From: Martyn White
Sent: 10 July 2019 17:03
To: Planning.Responses <Planning.Responses@arun.gov.uk>
Cc: Anita Gardner <Anita.Gardner@arun.gov.uk>
Subject: LU/149/19/L

LU/149/19/L

Number 41 Western Road is a grade II, early C19 Listed Building. It is a single storey structure with two pairs of sash windows. The elevations are rendered. There is a slate roof with eaves overhung and supported on 4 thin columns to form a veranda.

EXISTING FLOOR PLAN

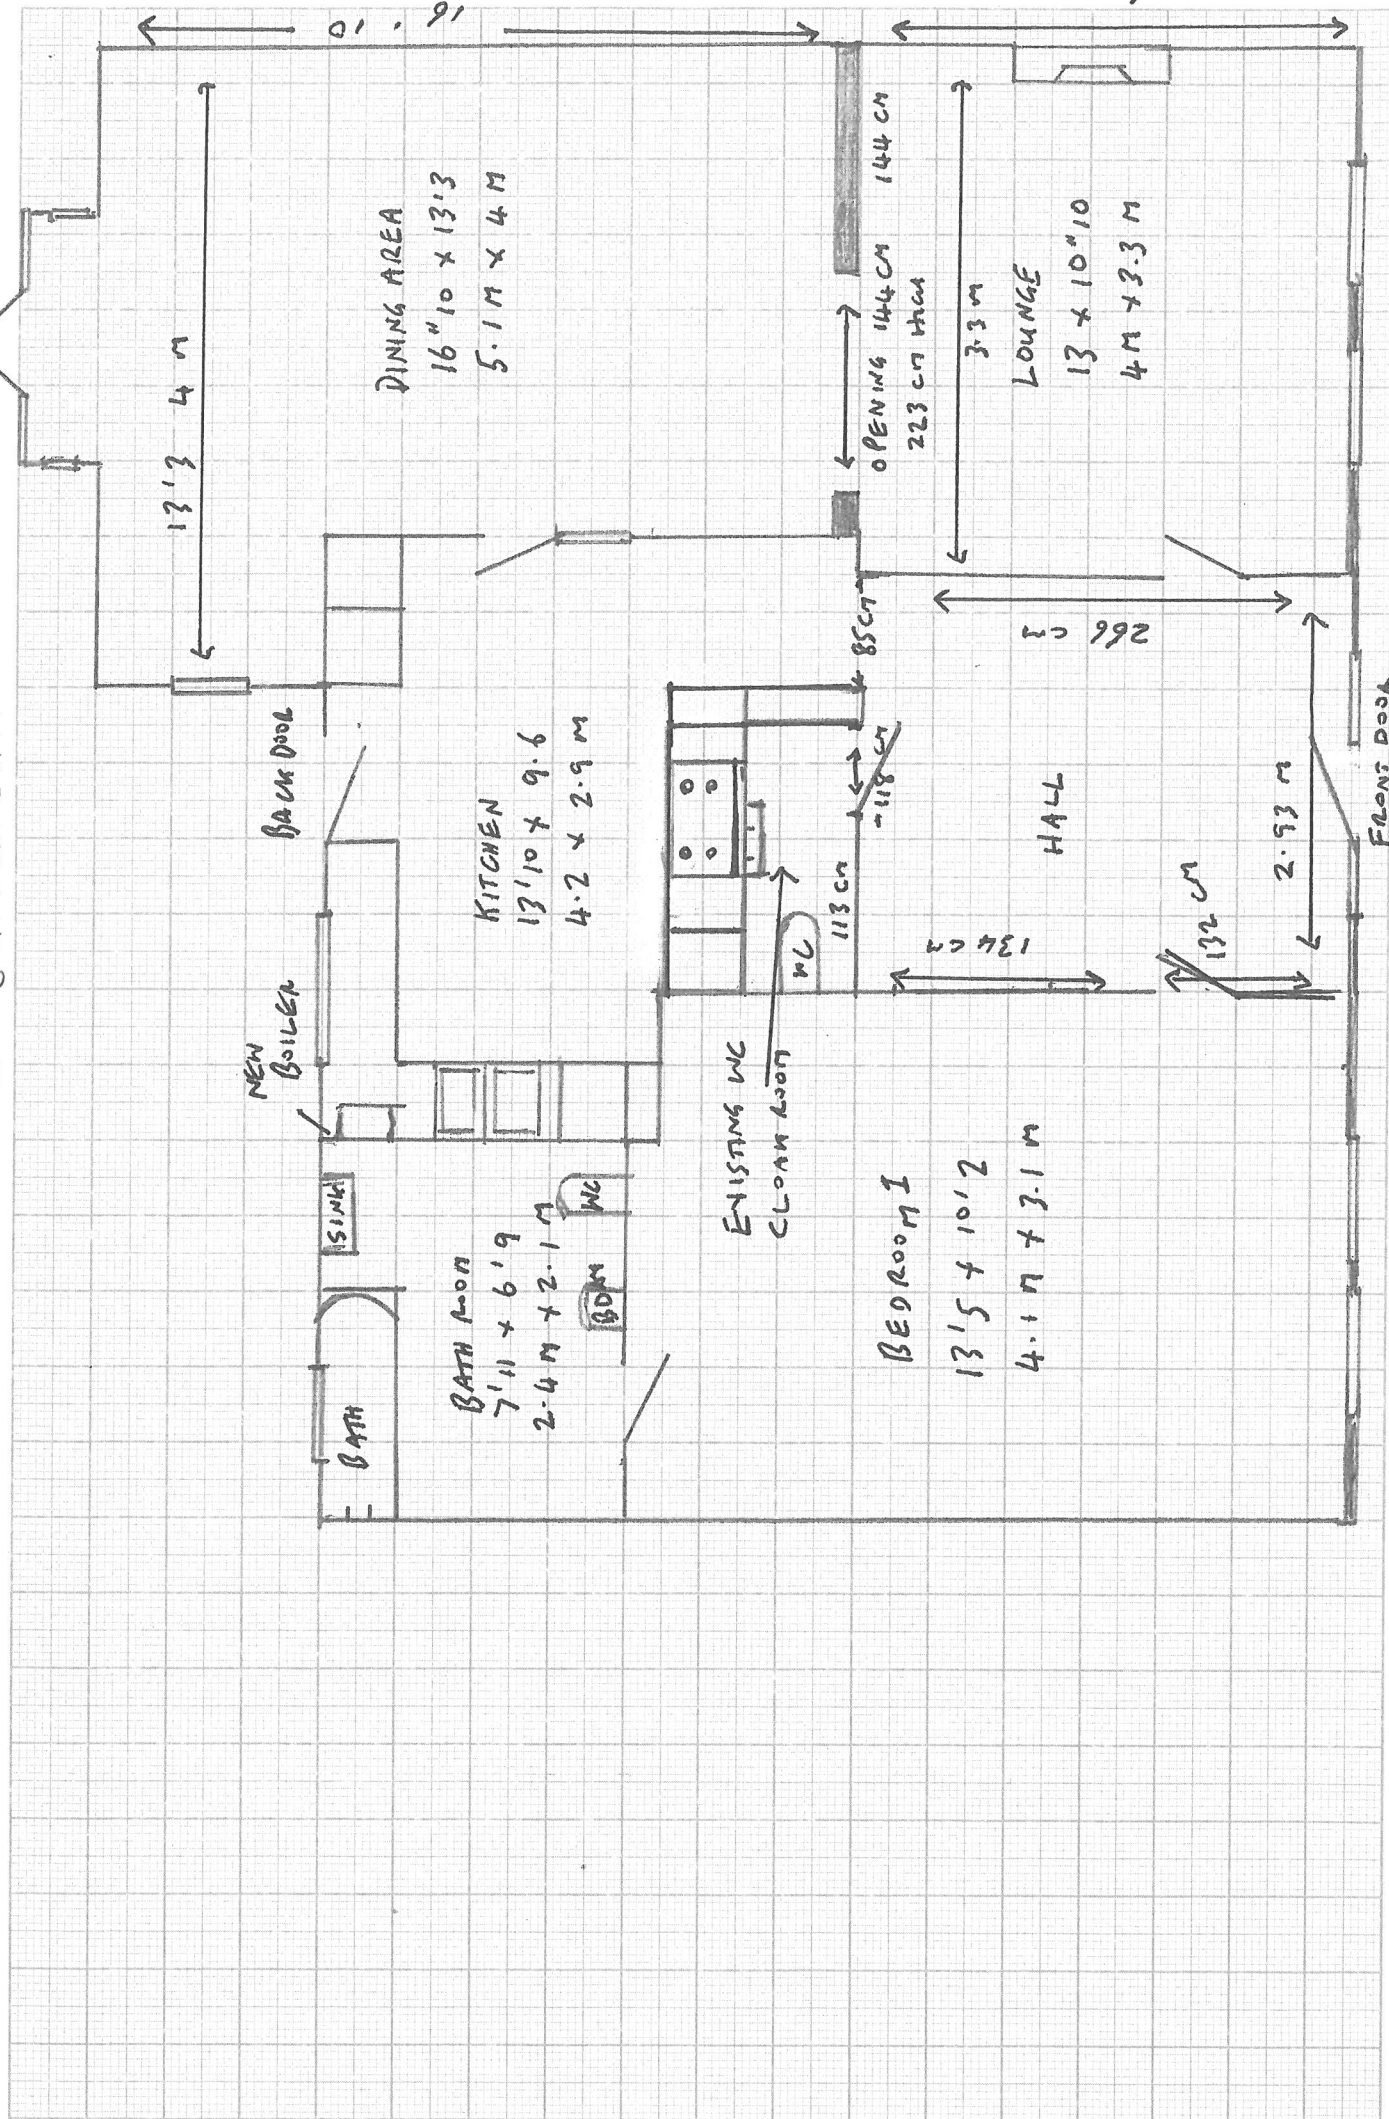
The internal works to enlarge the shower room and infill an existing opening will not harm the character of the building and can be considered to be acceptable. Likewise, as the flue is located to the rear of the building it should not be visible from the street-scene. It is recommended that this should be painted black.

The removal of the back boiler is acceptable, subject to any further alterations to the fireplace. I should state that if the fire surround is to be replaced, the design of this should be dealt with by way of condition
